Loreto Kirribilli Response to Submission

Concept Master plan and Stage 1

29 January, 2018 – Document ref – Rev 00

1.0 Response to Submission Schedule

W7

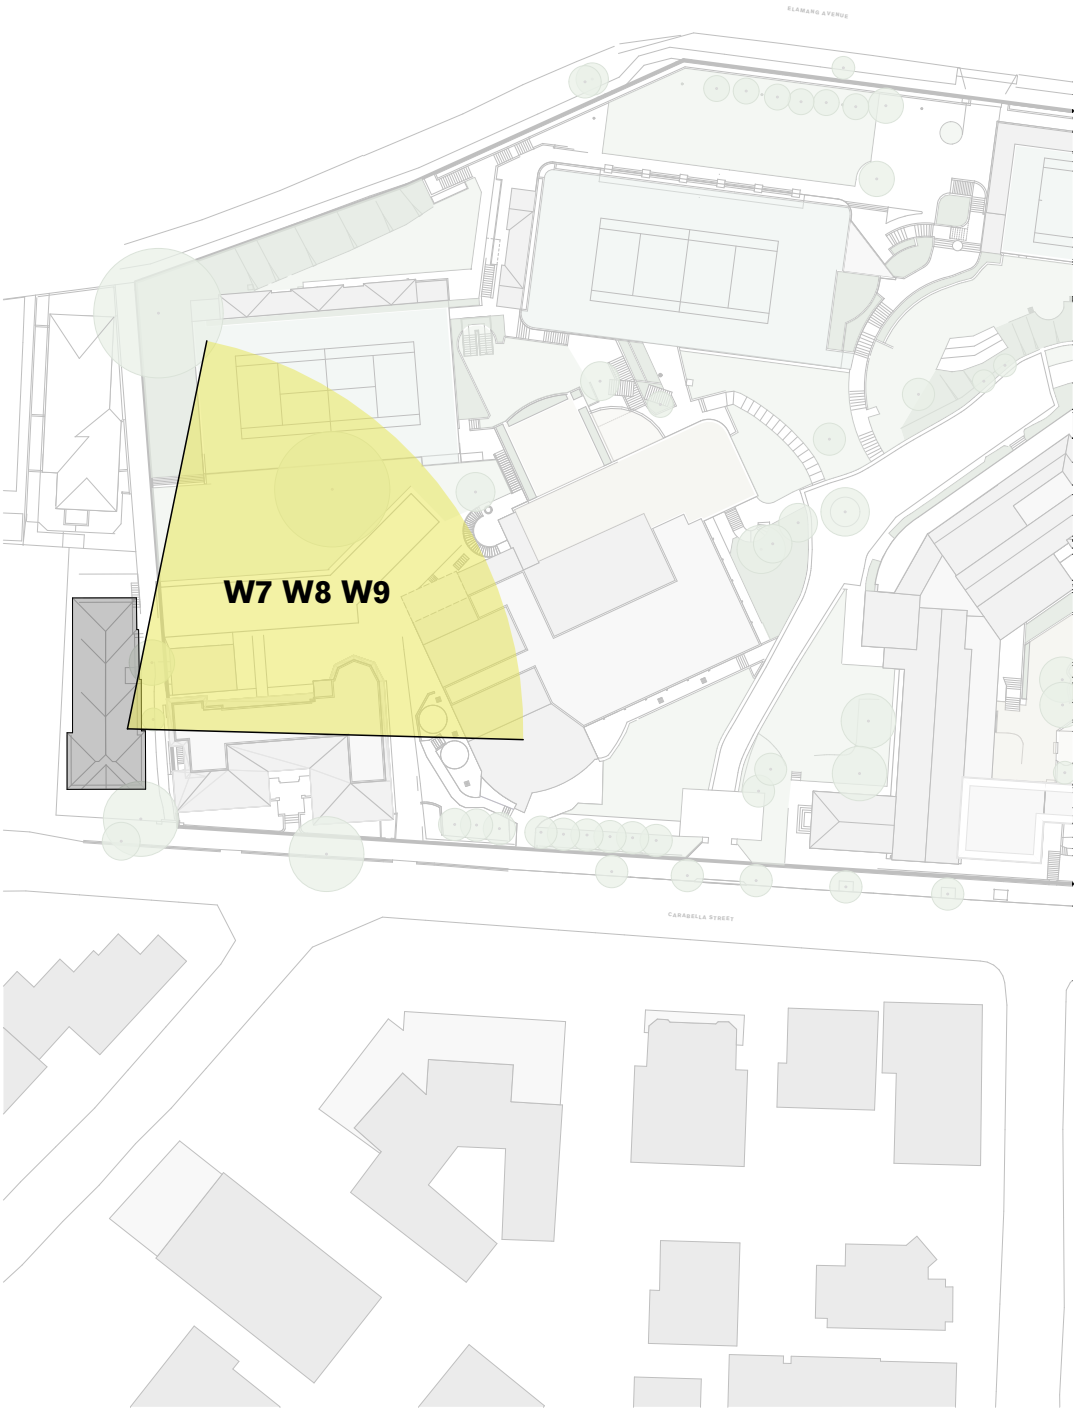
4.0	North Sydney Council	
4.1	Planning - North Sydney Local Environmental Plan 2013	
5.0	Views	
5.1	Concern is raised that there will be loss of views to high amenity water views currently afforded from the eastern outlook from 111 Carabella Street, Kirribilli. A reduction to the height and depth to the building can ameliorate the potential impact.	Refer response to item 2 and SKMP- 60.4

It is acknowledged that the proposed development envelope will obstruct the existing harbour views, however this portion of the obstructed view is within the complying envelope (as indicated in orange). In order to maintain the harbour views illustrated in the provided photograph the height of the development would be required to match that of the existing B-Block at RL33.620 which is approximately 3m below the allowable 12m LEP height plane.

The non compliant elements as indicated in red include the lift overrun. This protrusion of this element above the LEP height plane is considered a minor impact.

W23 Bedroom

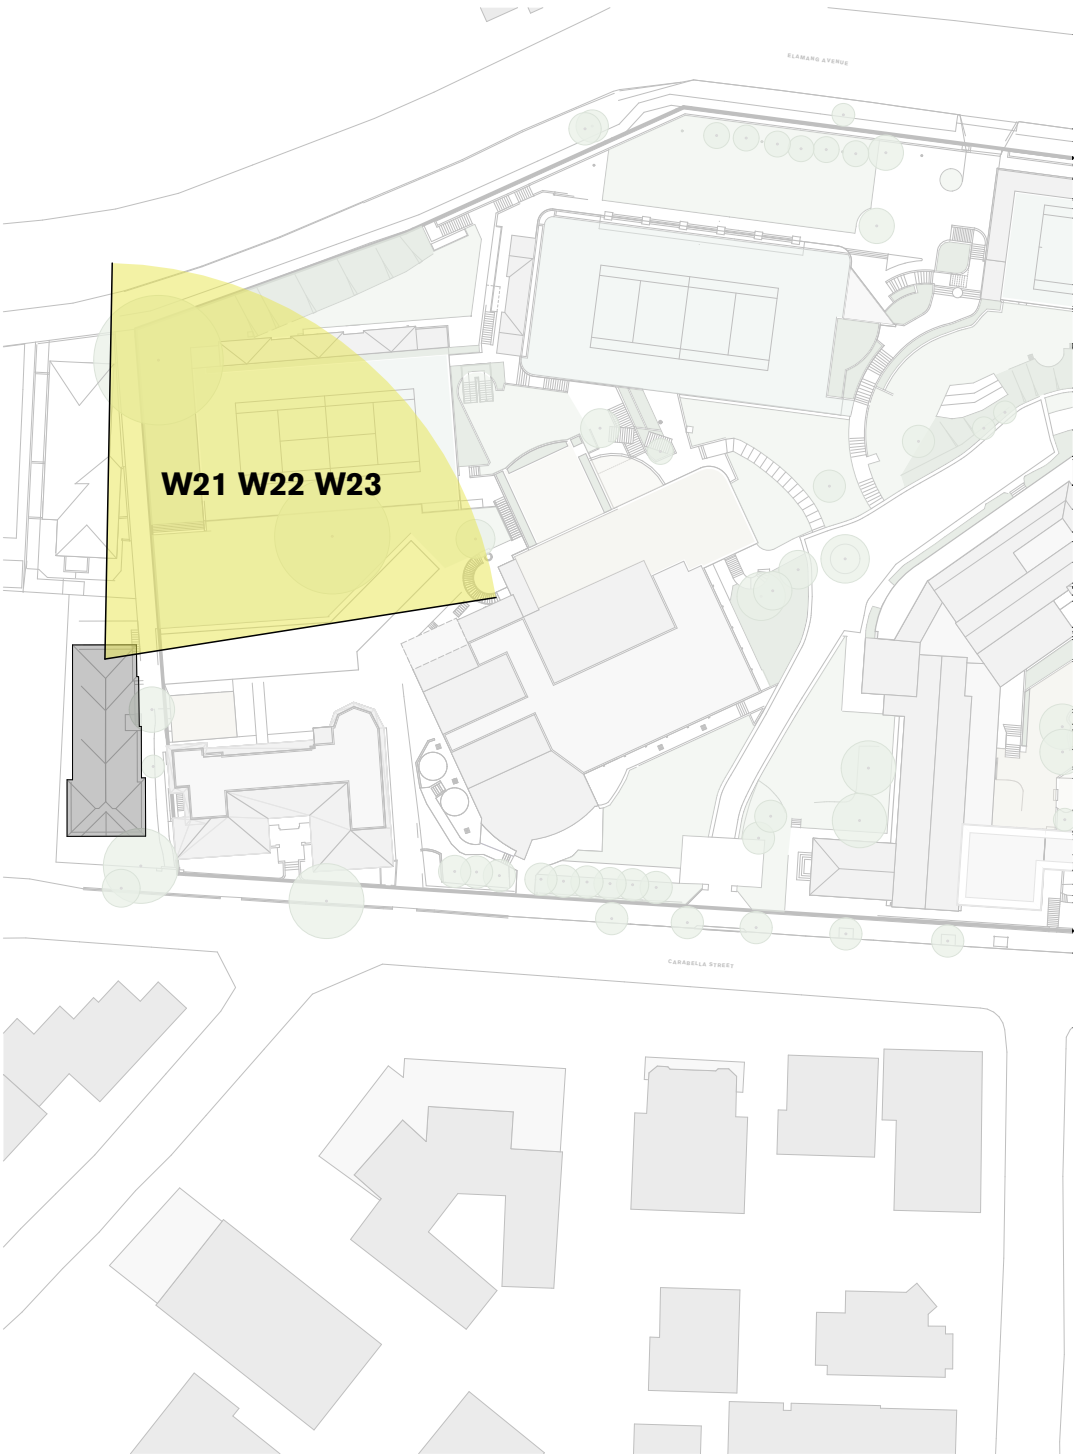
Picture 3 incorrectly references W21 from the View Analysis Report. This photograph has been taken from the bedroom /study and should be referenced to W24 for comparison. Refer view from W24 (Drawing Sheet MP-61111 from the View Impact Assessment). From this view, there is no impact.

In regard to the view from W21, W22 and W23 views were tested from a number of angles to assess the percentage of overall view loss. Refer to the below image and attached drawing sheet SKMP-60.1/SKMP-60.2 for further details. W21 is taken from a worse case view point looking obliquely across the school site however when looking directly out of the window (Total View) there is no impact to the existing views. Also to note as illustrated below the view obstruction attributed by the non complying portion (shown in red) is considered to be relatively minor when considering both the total view and the oblique view and is the result of the non compliance with the DCP height plane, rather than the 12m LEP height control. W21 shows a small portion of harbour view loss and W22 shows small portion of sky loss from the non compliant envelope. Therefore the overall percentage view loss is considered to be minor.

title
**Proposed Plans
Masterplan Proposed Plan - LG4 LG3**

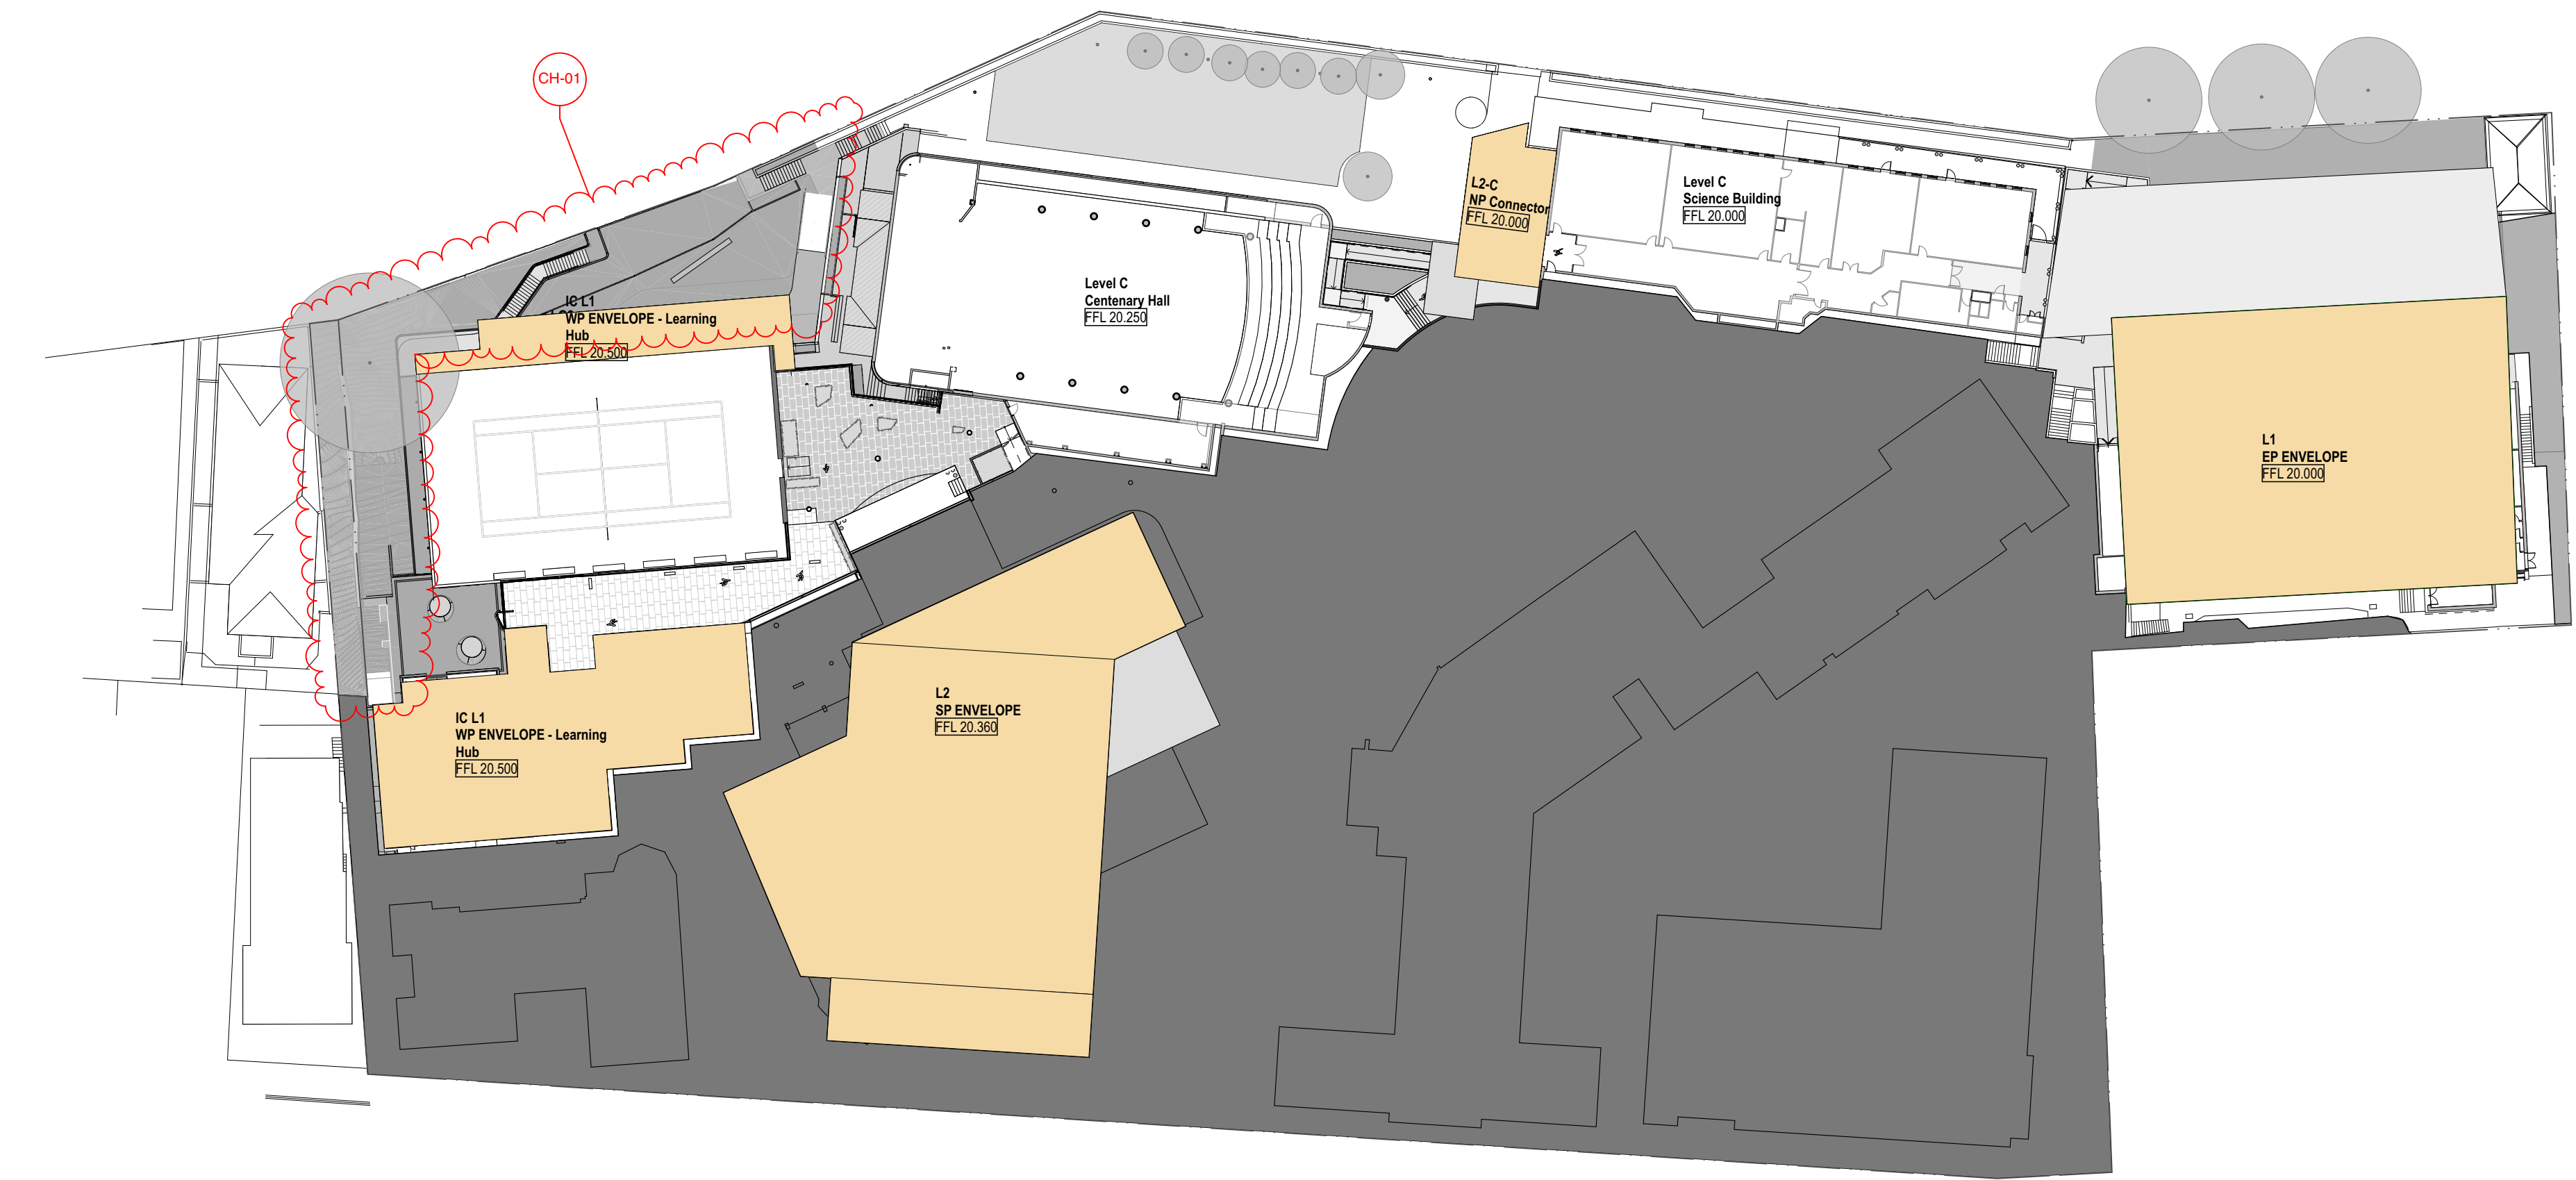
3.6	Satisfactorily provide natural light and air to all learning spaces including the PDHPE classrooms in Lower Ground 3 and 4 of the Learning Hub.	Refer Figure 3
